Our Ref: WA/98/16/CLE
Your Ref:

Application for Lawful Development Certificate for an Existing Use or Operation or Activity including those in breach of a planning condition.

Development Application for a Lawful Development Certificate for an existing use of land for siting 1 No residential mobile home.

Location Cherry Tree Nursery Eastergate Lane Walberton

PLAN 1

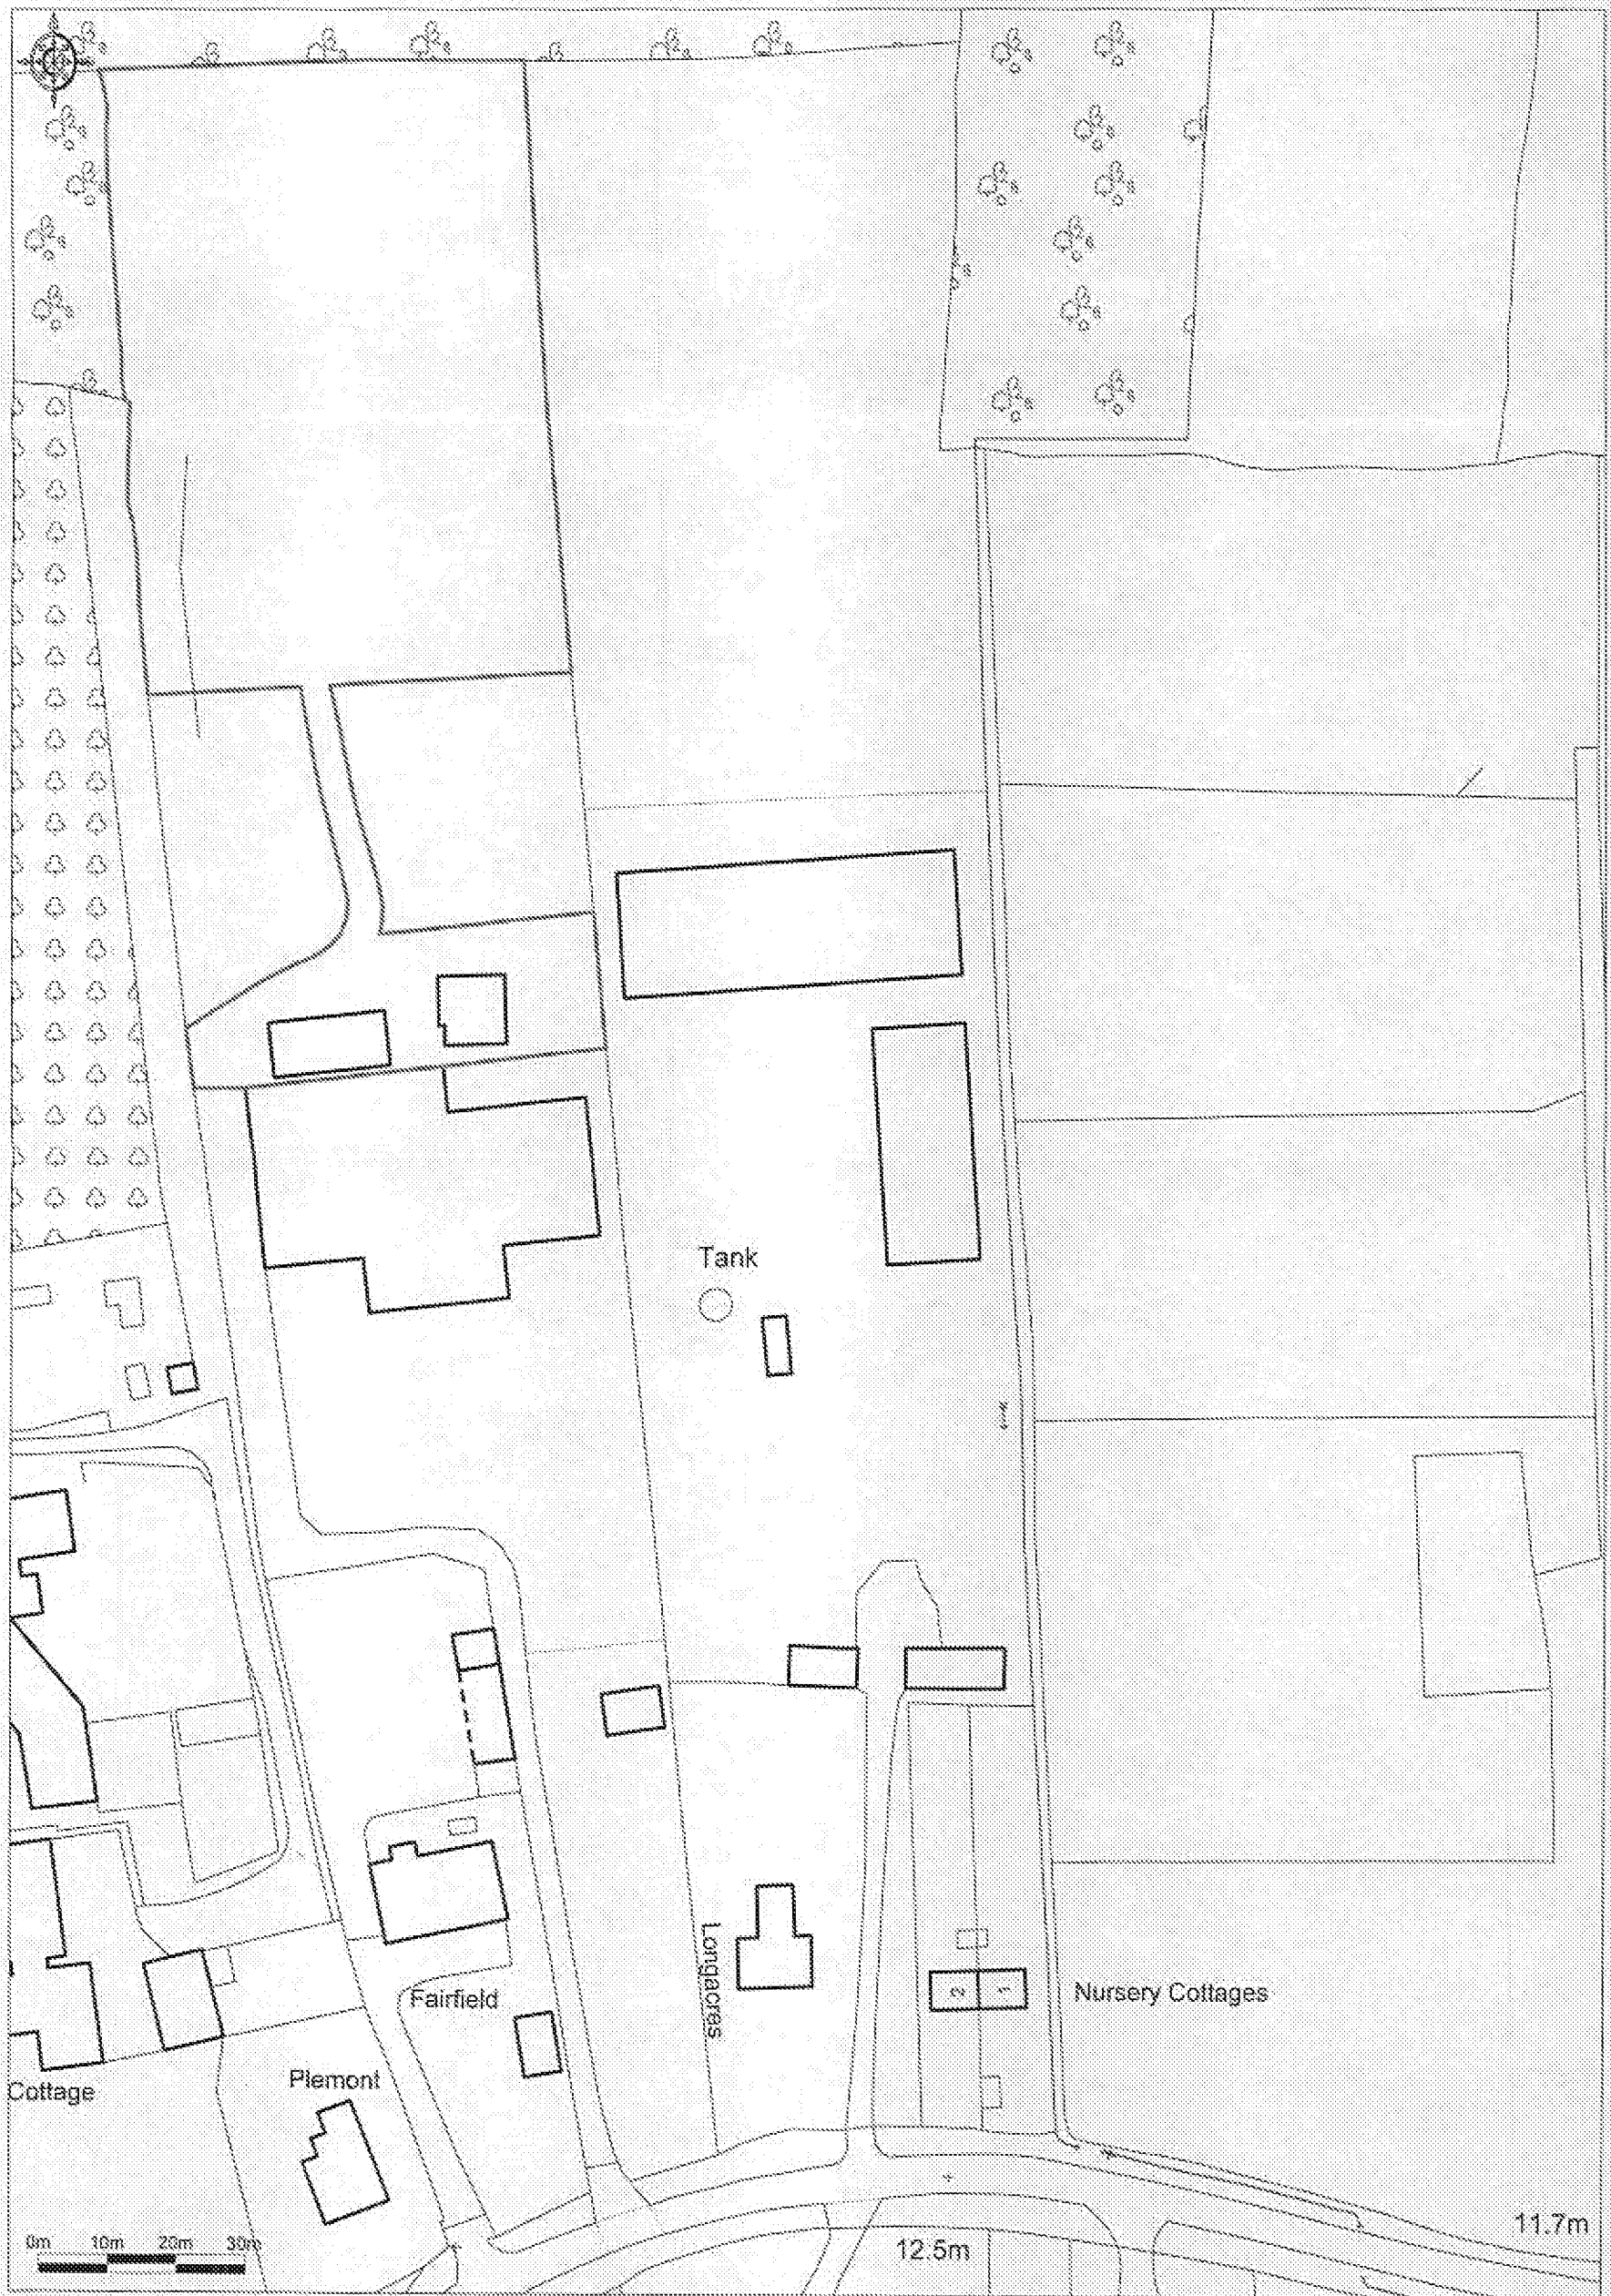
Location Plan

Please submit 1 electronic or 3 paper copies of an amended location plan at a scale of 1:1250 or 1:2500 for rural areas to include the access to the site from a highway shown within the red edge. Further details of what must be included on the plan can be found in the National Validation Requirements.
